CITY OF ALBUQUERQUE

Re: Smith's Fuel Center # 446, 6301 Lomas Blvd NE,
Request for Permanent C.O. - Approved
Engineer's Stamp dated: 6-08-09 (J-18/D015)
Certification dated: 02-08-11

Based upon the information provided in the Certification received 02-09-11, the above referenced Certification is approved for a release of a Permanent Certificate of Occupancy by Hydrology.

C4.1

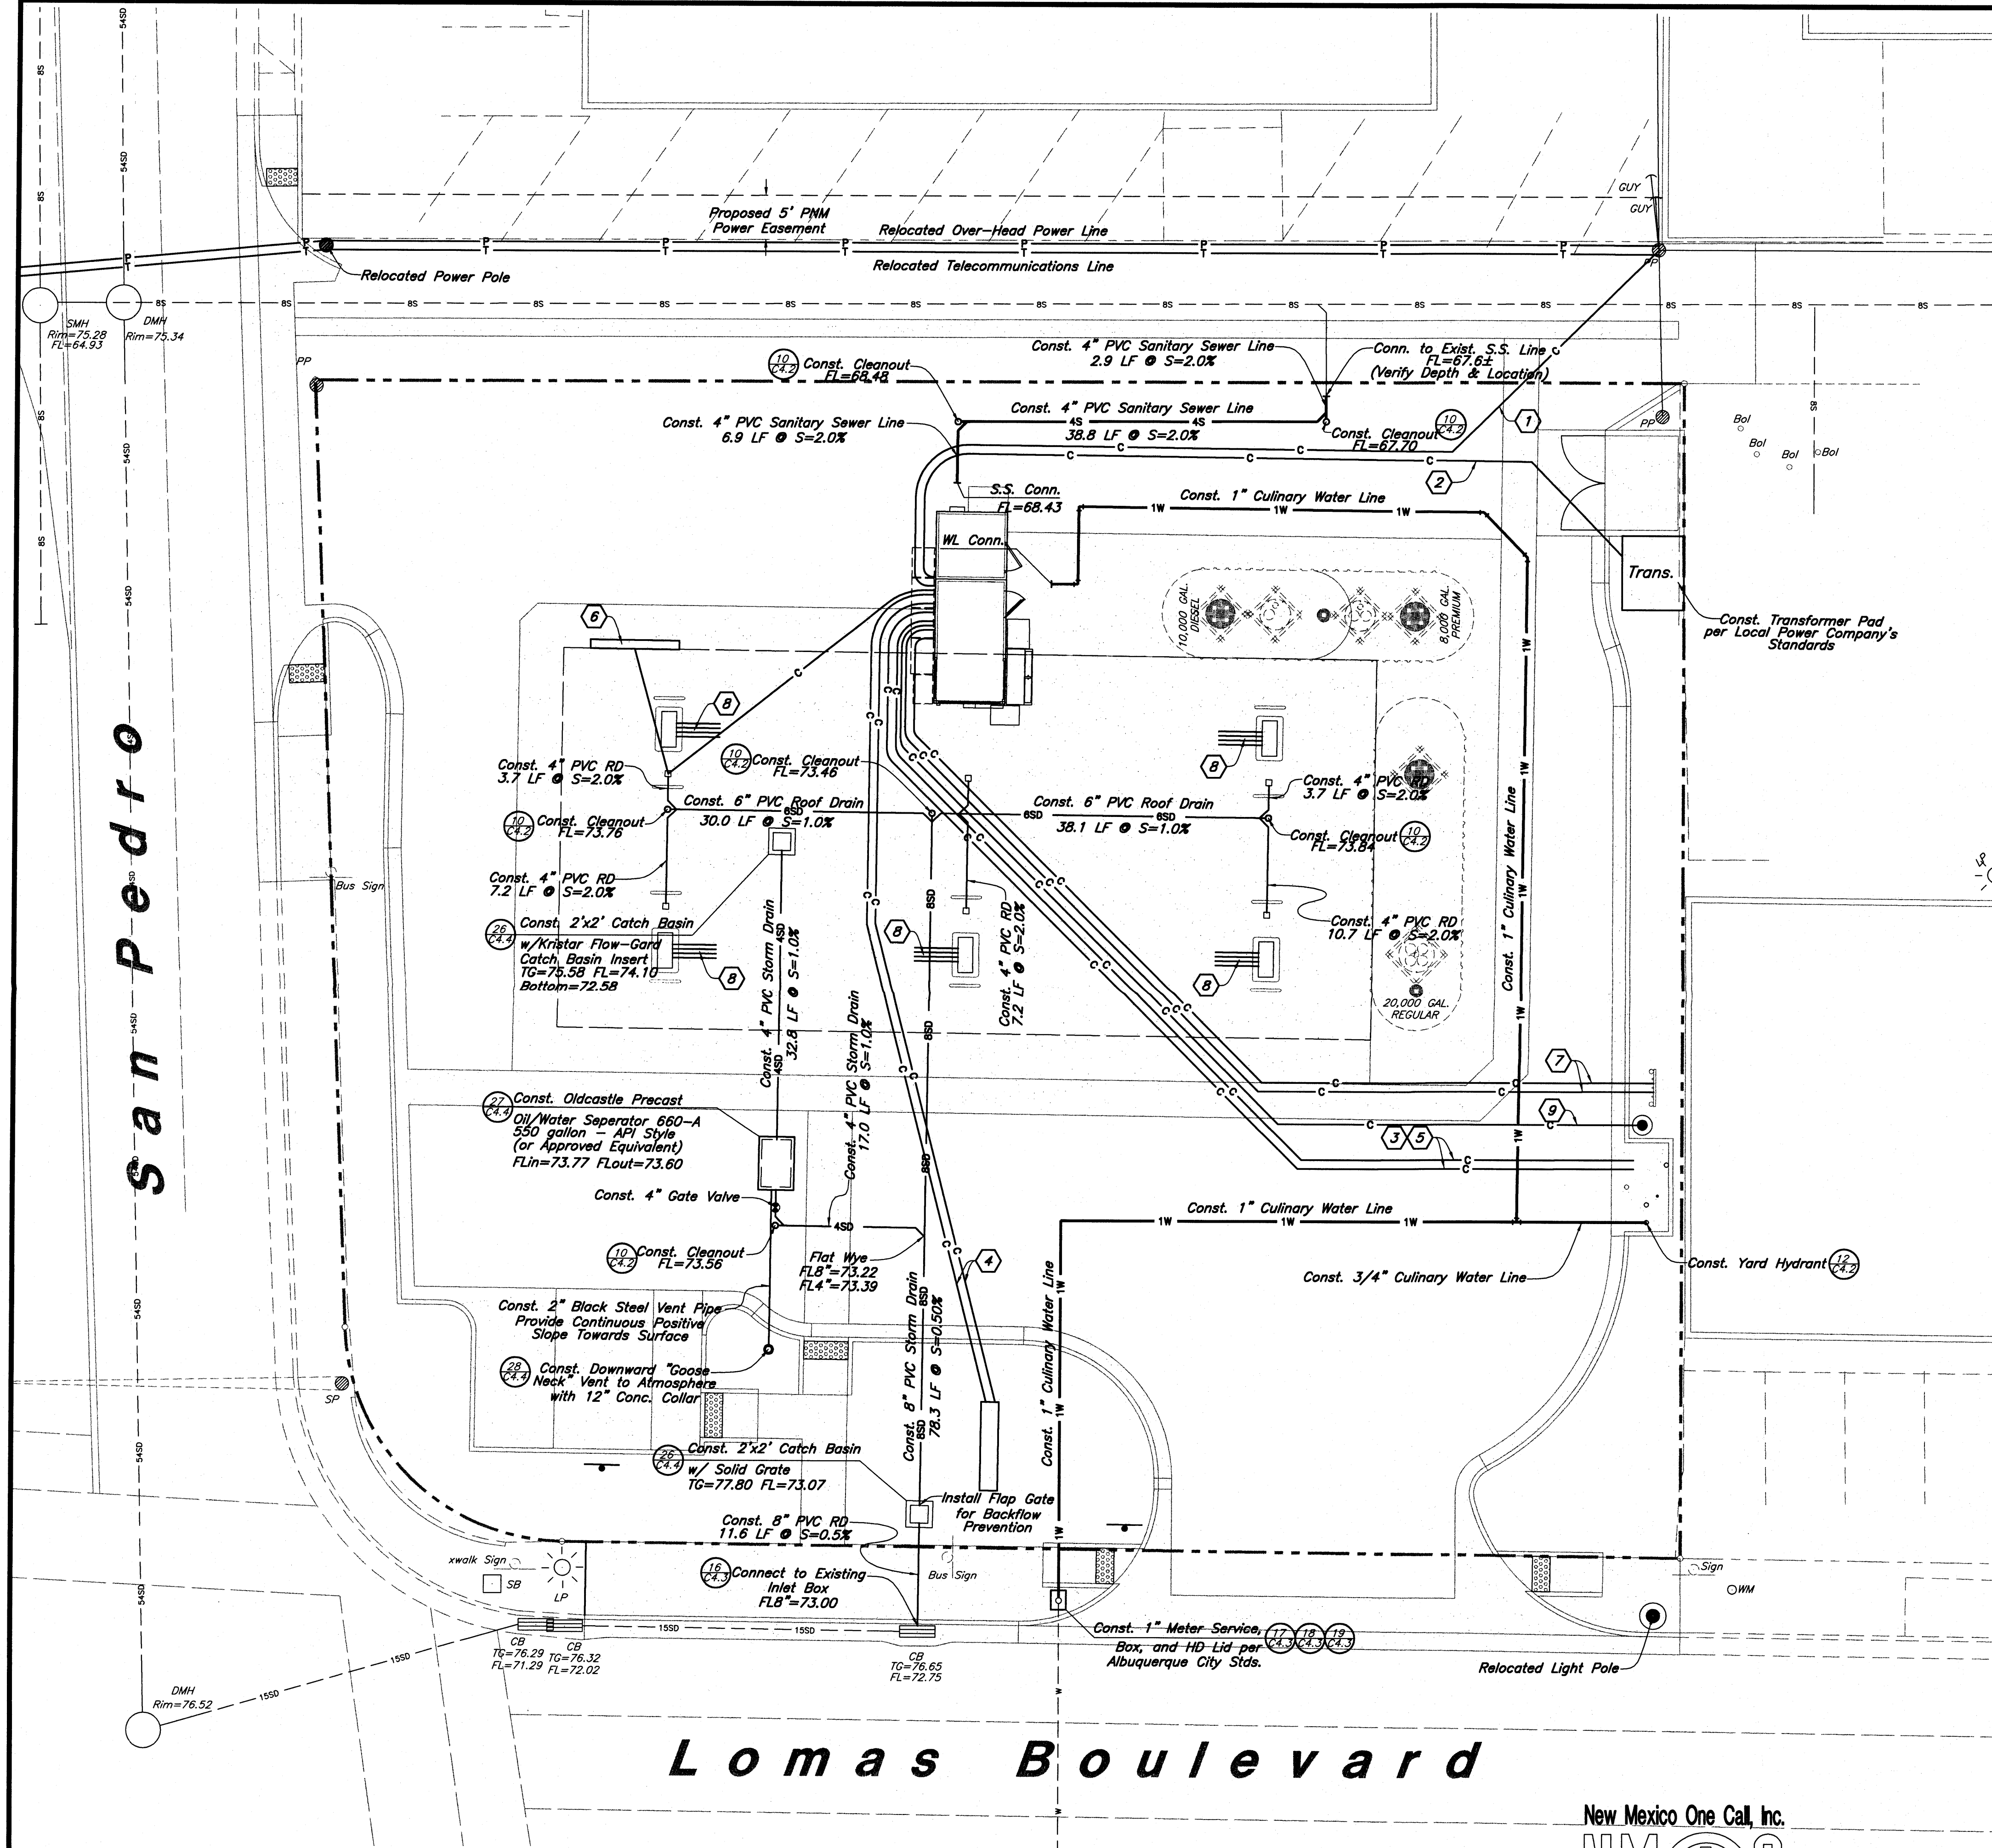
- ~~4. A six-foot wide, ADA accessible pathway must be provided from public sidewalk to the building.~~
- ✓ 5. Provide a copy of detail sheets C4.1 and C4.2.
